Subject: EES comments on Response to Submissions - Modification Application for Lane Cove West Data Centre – SSD-9741 MOD 1 – 1 Sirius Road Lane Cove West

Subject: EES comments on Response to Submissions for Modification Application - Lane Cove West Data Centre – SSD-9741 MOD1 – 1 Sirius Road Lane Cove West

- Response to Submissions for MOD 1 – 17 March 2020
- Appendix 1 – Landscape Plans
- Appendix 2 - Landscape Design Report (LDR) – issue G – 11 March 2020
- Appendix 3 – Geoscapes letter of 12 March 2020
- Appendix 4 – Travers Bushfire and Ecology letter of 13 March 2020

DWG No:
LDA-05

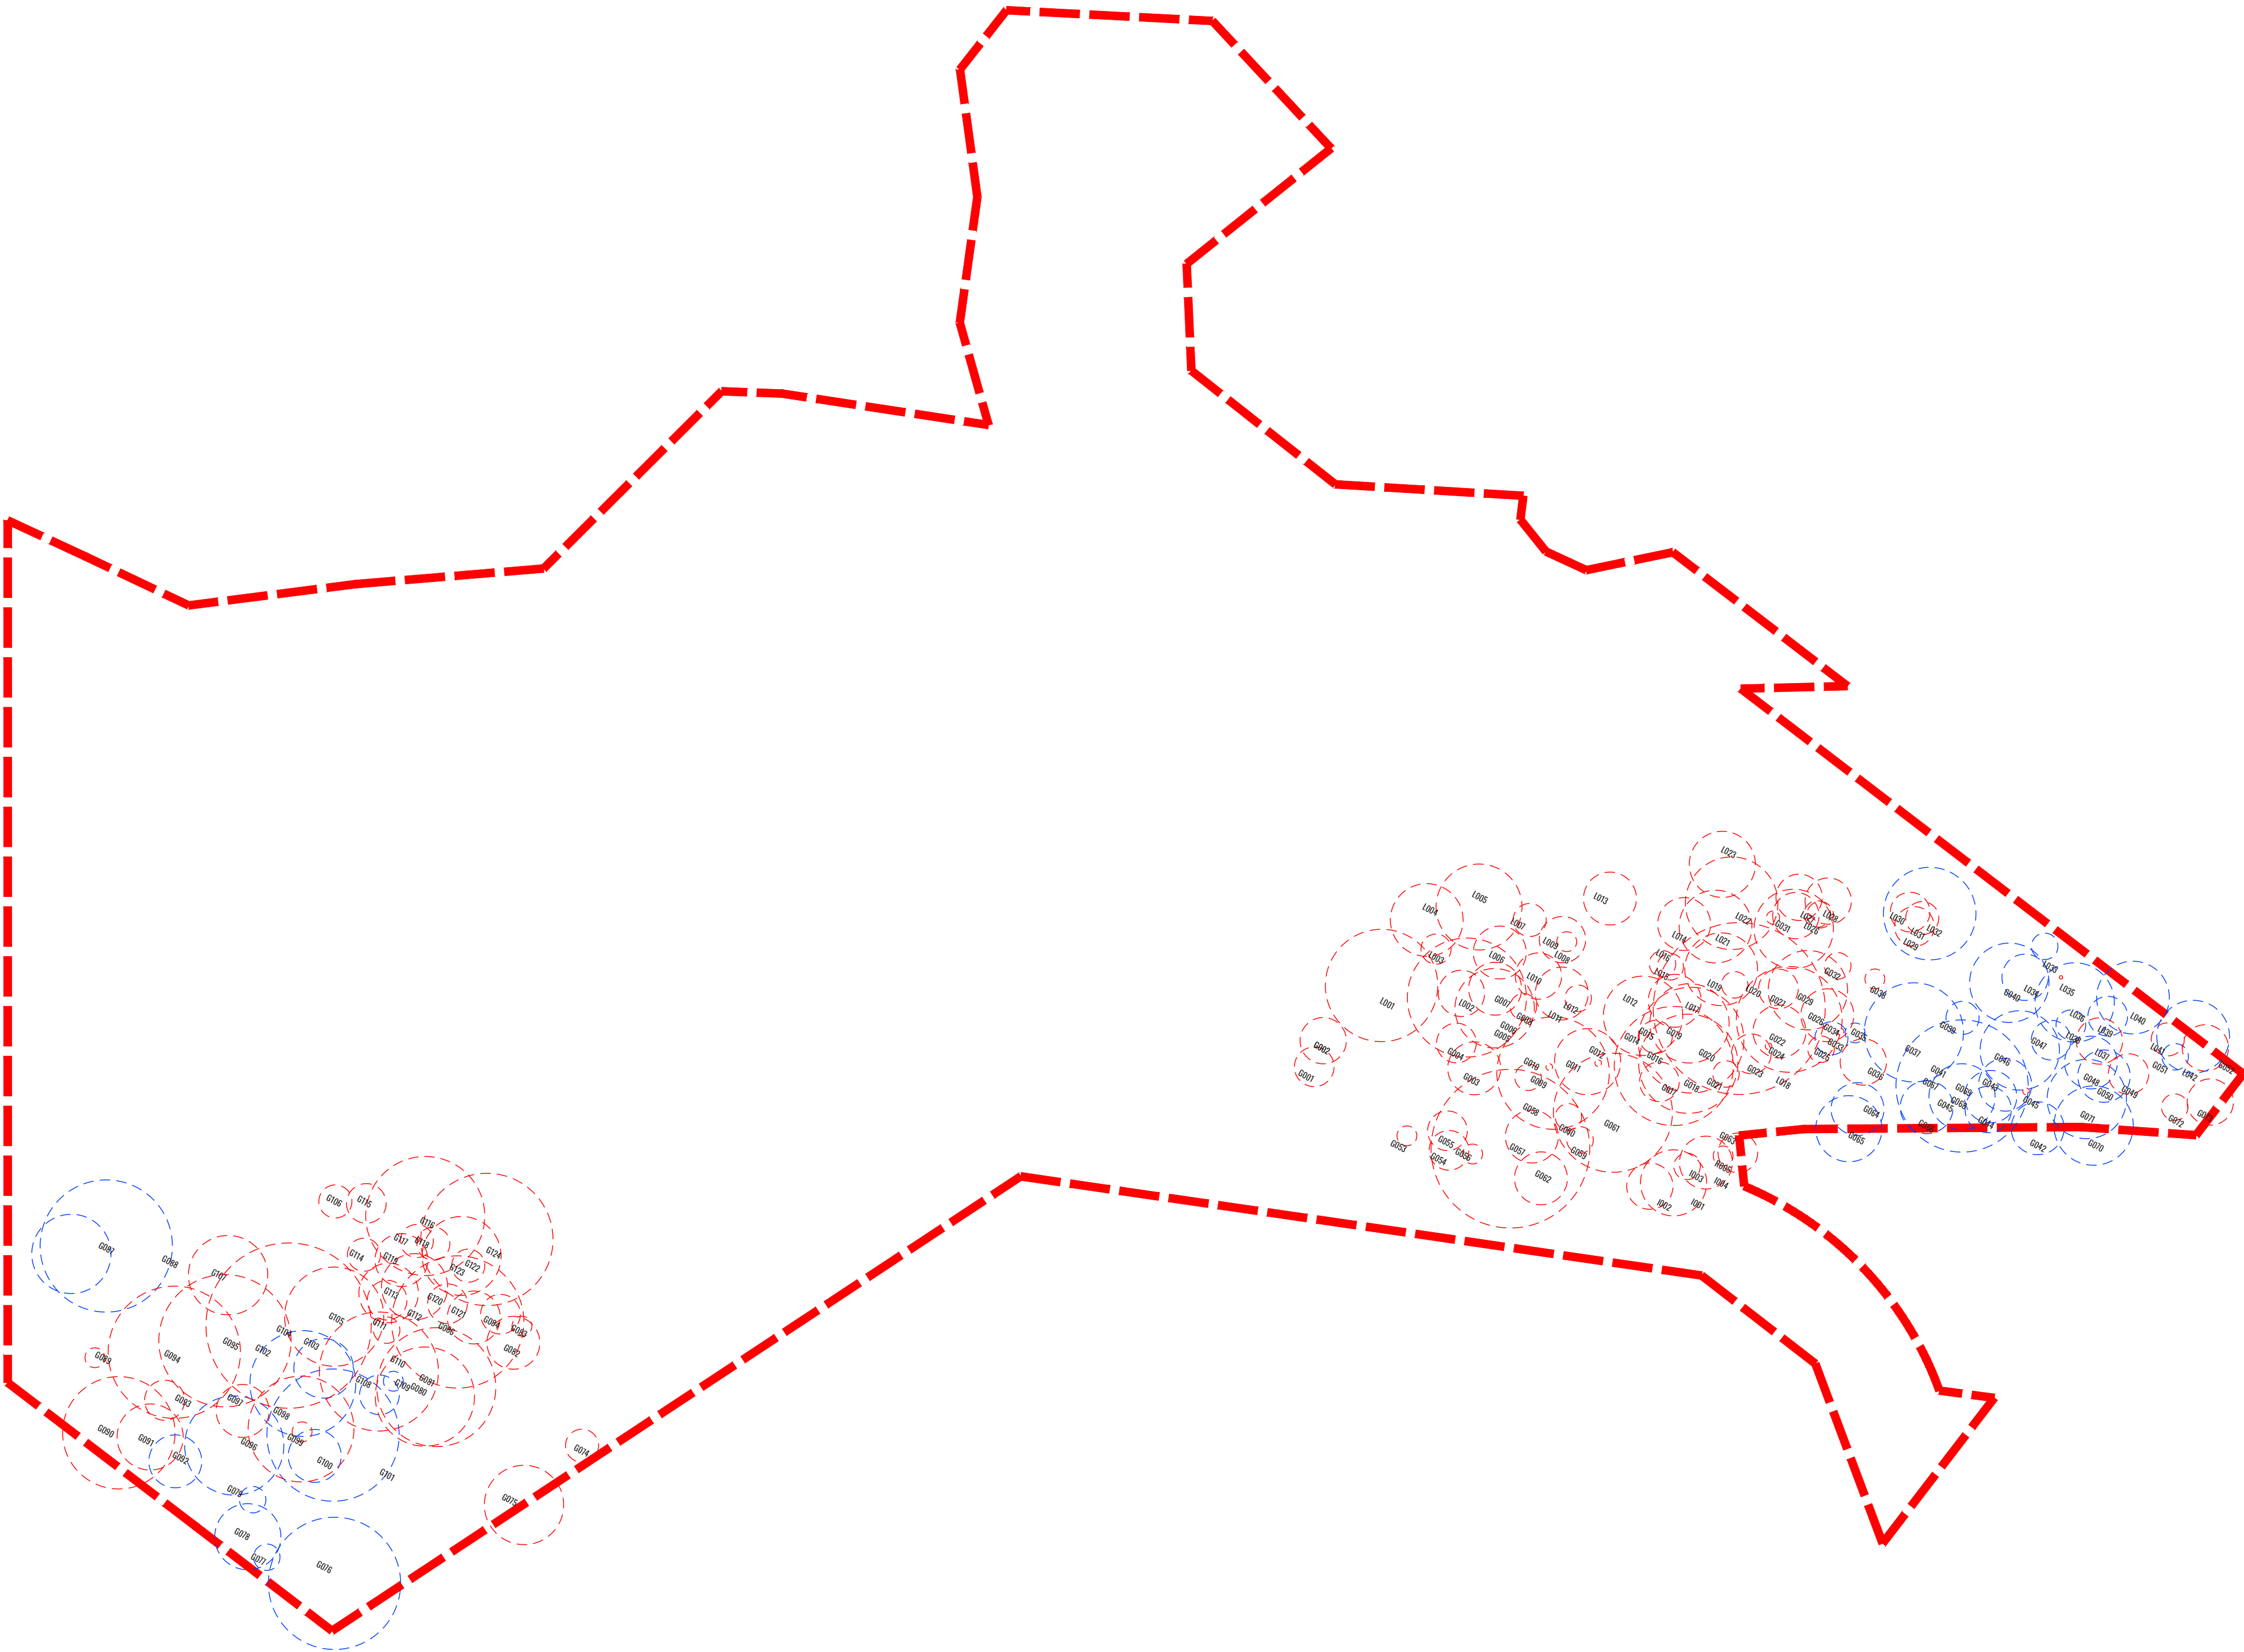
In its submission of 3 October 2019 for SSD-9741, EES recommended 11 invasive trees that were shown to be retained on the landscape plan (LDA-05) be removed. A revised TAR has not been provided with the RTS but EES notes the Landscape Plans submitted for MOD 1 EA and RTS show all exotic trees are to be removed.

All invasive tree species should be removed from the site and an ongoing maintenance program implemented to regularly control and remove invasive species from the site as per the recommendation in the VMP for SSD-9741, particularly as the Lane Cove National Park is located to the west of the site
